Listed Building Consent Delegated Report

Application No.	23/02175/LB
Site Address	Rosemary Cottage, Somerton Road, North Aston, OX25 6HX
Proposal	Replacement windows to annexe at Rosemary Cottage; door with glass side panels to be fitted with a new aluminium floor rail, added bottom rail/false bottom rail and security lock/handle
Amended Plans	None received

Subject:	Measure:	Date:	Rev. date:	Drawingnr.:
Proposed window Side section	1:5	20.10.2023	-	1.031/N 01

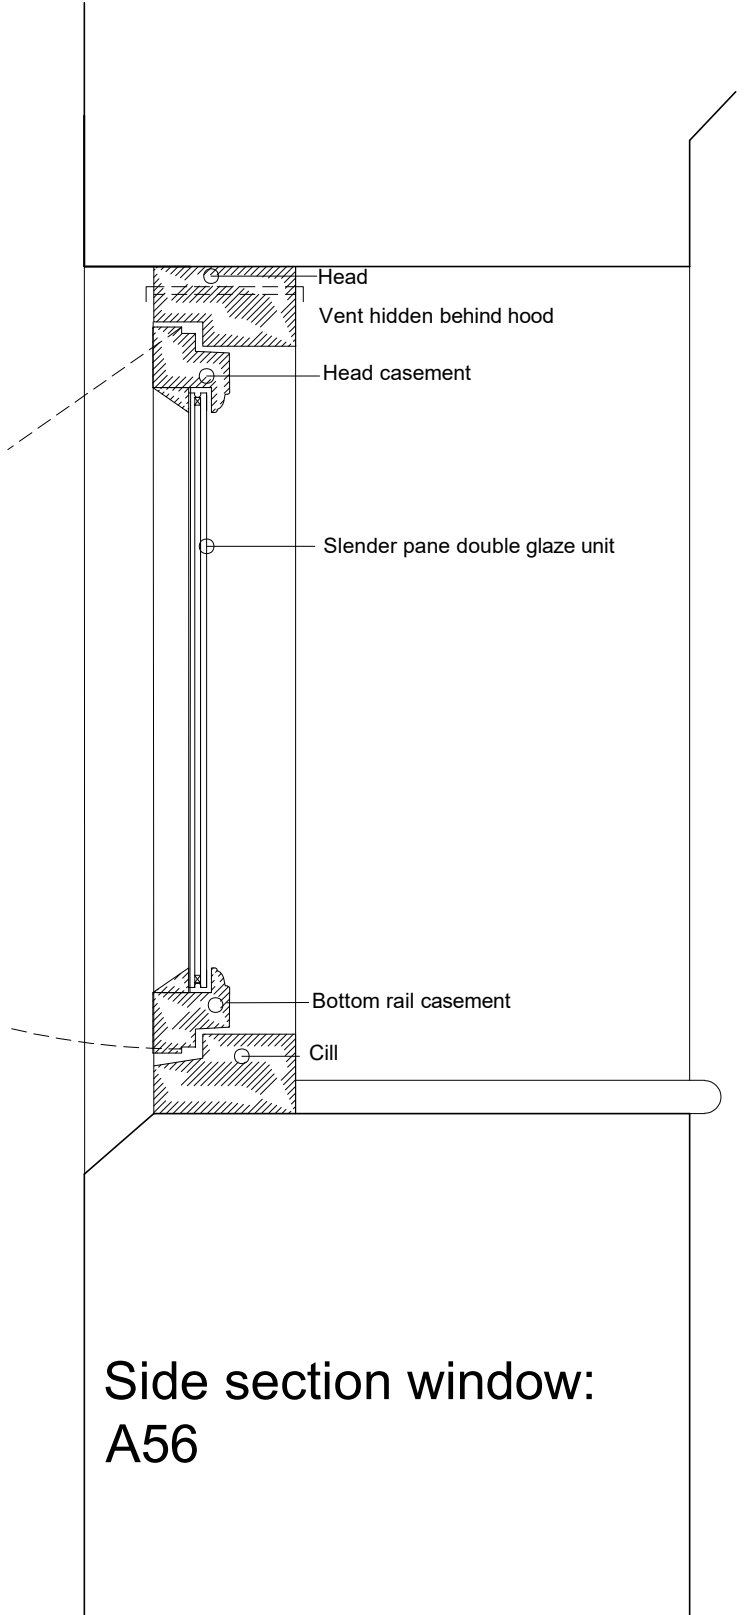
3. Ward Councillor - No response.
	4. Conserva•on (CDC) - Objection. See below. <ul style="list-style-type: none"> • Further information has been submitted which does demonstrate that the proposed windows would have true integrated glazing bars, would be flush fitted and would generally be traditionally designed and detailed. • However, it is still proposed to have double glazed units as opposed to single glazing. As commented previously double glazing is usually only ever acceptable when there is a visual benefit to the listed building and there does not appear to be a real benefit to the listed building in this instance as the existing window designs are not necessarily inappropriate or harmful in their design. • As such, although the proposed windows would appear to be traditionally designed, it is the double glazing itself, and resulting visual appearance/impact, where there are concerns. This is because double glazing can give double reflections and appear non-traditional, resulting in a visual disparity. • Consequently, it is considered that there would be a low-level of less than substantial harm to the heritage asset.

CDC Conservation have objected to the proposal as outlined above – design OK by potential window glare.

The Planning Officer agrees with the Conservation Officer in that a low-level of less than substantial harm to the heritage asset would occur from the installation of the proposed windows. However, the Planning Officer disagrees with CDC Conservation that the double glazing itself and resulting visual appearance/impact are sufficient in themselves to substantiate a reasonable objection to the proposal and would not result in a visual, non-traditional disparity.

The applicant has indicated that the windows would be manufactured in a suitable hardwood, with thin Pane double glazing units, Putty Beads/Ovolo glazing bar. Fitted with washer butt hinges, multi-lock furniture and trickle vents to help ventilate the building.

Such windows are considered to be appropriate in this case and would allow the building to continue to be used for residential accommodation in a sustainable manner with improved energy efficiency.
